SHD0019/22 North West Corner of Omni Park Shopping Centre, Santry Hall Industrial Estate, Swords Road, Santry, Dublin 9.

Comments by DCC Parks, Biodiversity & Landscape Services

October 14th 2022

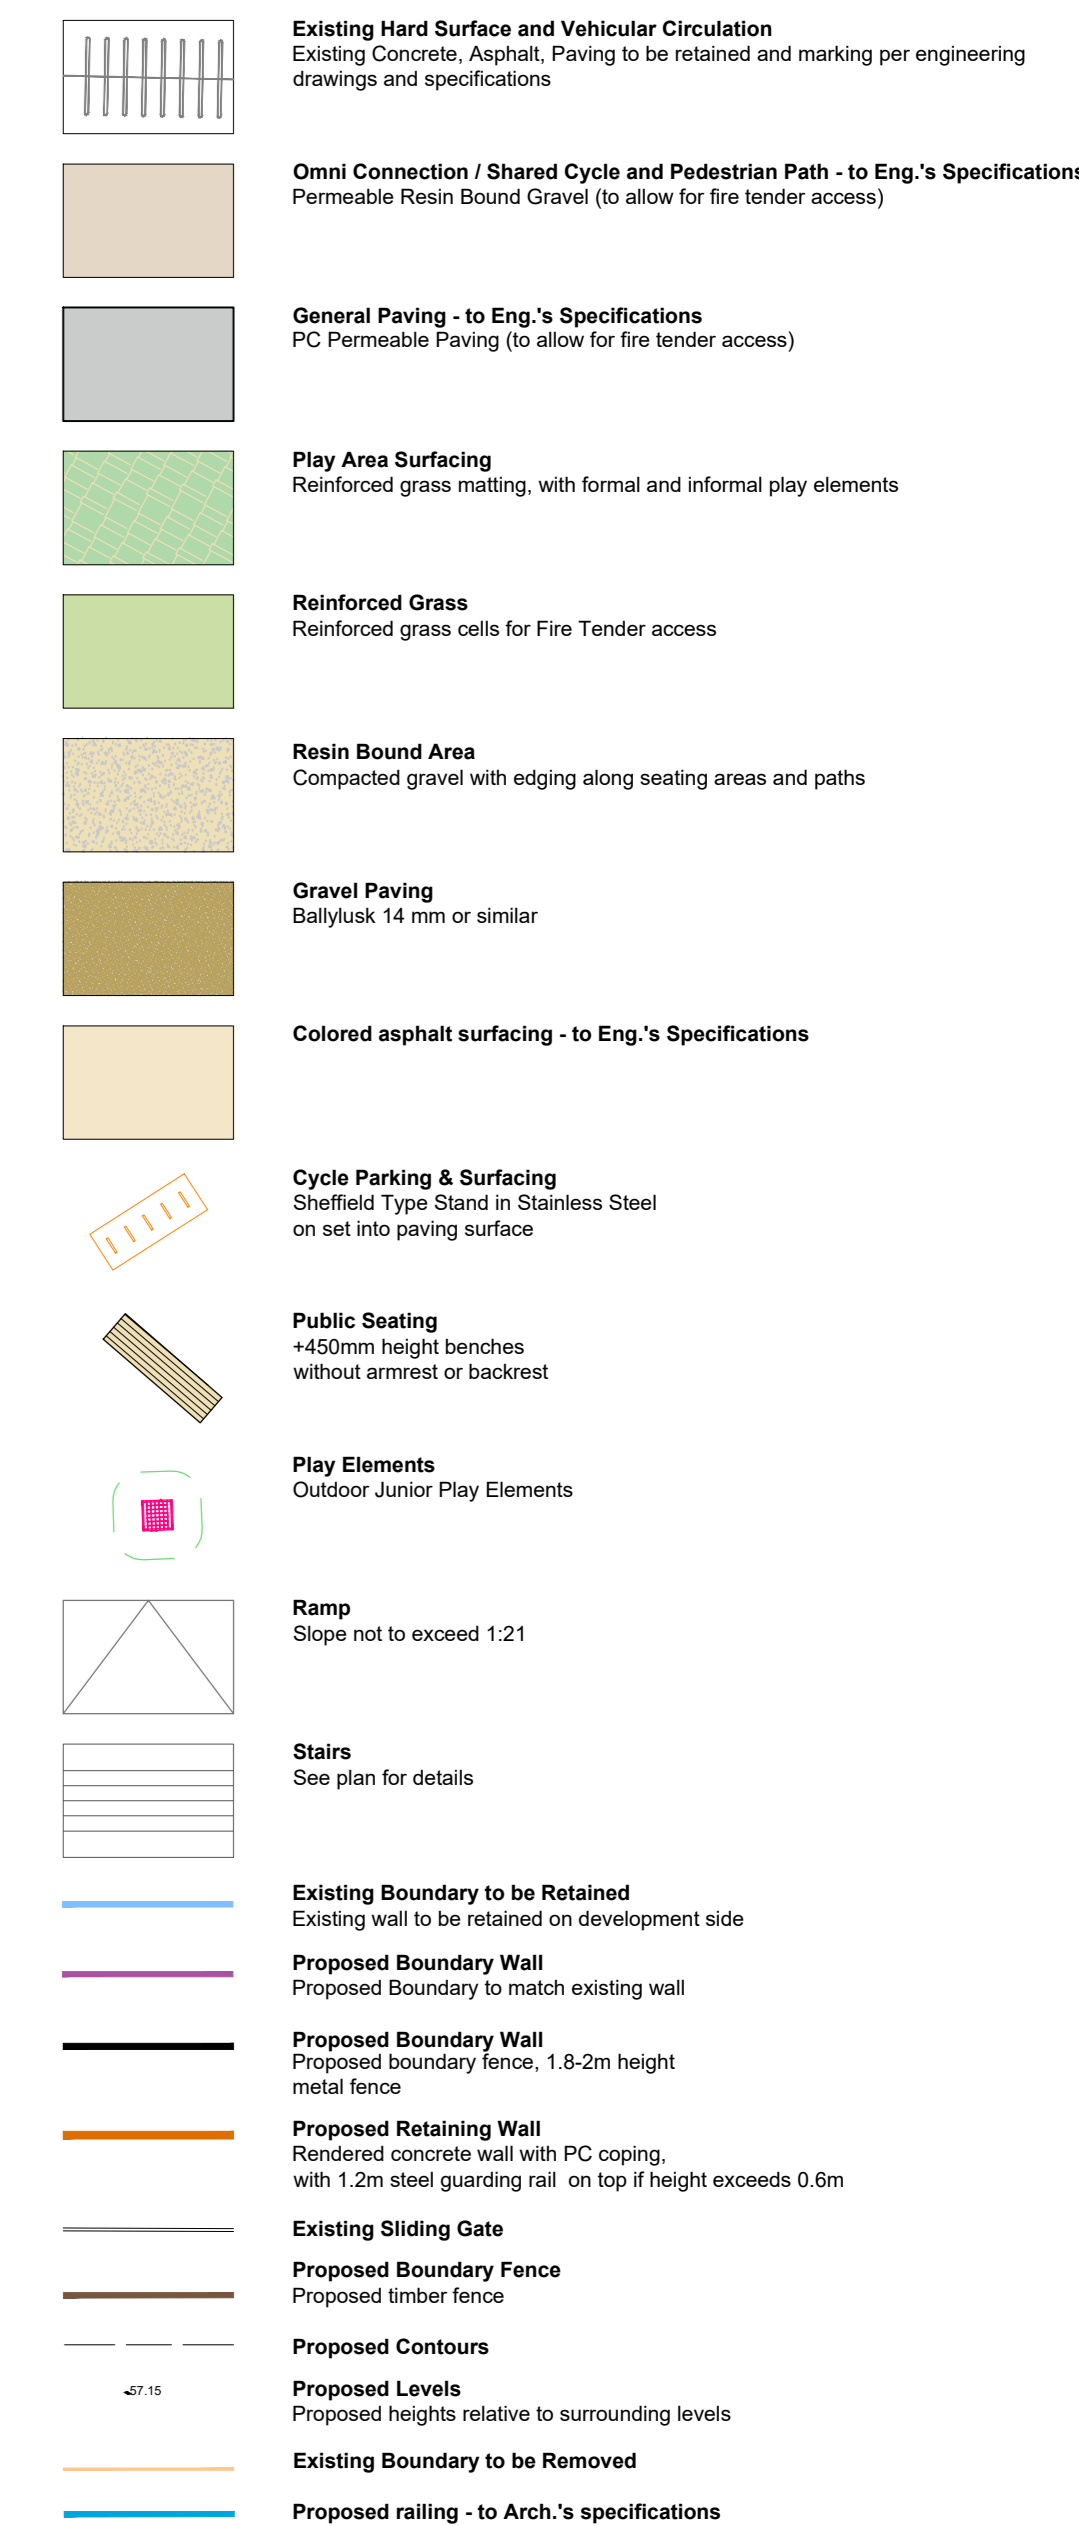
The quality of the materials used within the plaza should be improved with the full use of natural stone surfacing. In addition, the use of large-canopy tree species and public art shall help to improve greening and sense of identity to the development.

The application indicates a provision of 3552m² which meets the required 2802m². COS should be distinct from public areas by use of boundaries so that privacy and security is maintained for future residents. Additional active recreational elements, such as basketball half court, external gym units should be included. Play space generally meets guideline requirements.

The crèche external play space shall be fully enclosed.

The tree survey submitted indicates limited tree removals due to car parking rearrangement adjacent the Santry Road pedestrian link. Other off-site trees with canopies overhanging the site western boundary should not be impacted due to the building positions, however a tree protection fence to the extent of the canopies should be installed. There will be substantially more new tree planting under the landscape scheme to compensate for proposed tree removals.

- a. The public open space with all paved areas constructed in natural stone.
- b. The enclosure of communal open space areas.
- c. The inclusion of active recreational elements (basketball & external gym units) within the communal open space.
- d. The enclosure of the crèche play-space.
- e. A high quality public artwork in the public open space plaza.
- f. The expansion of green roofs coverage on all flat and gently sloped roofs.
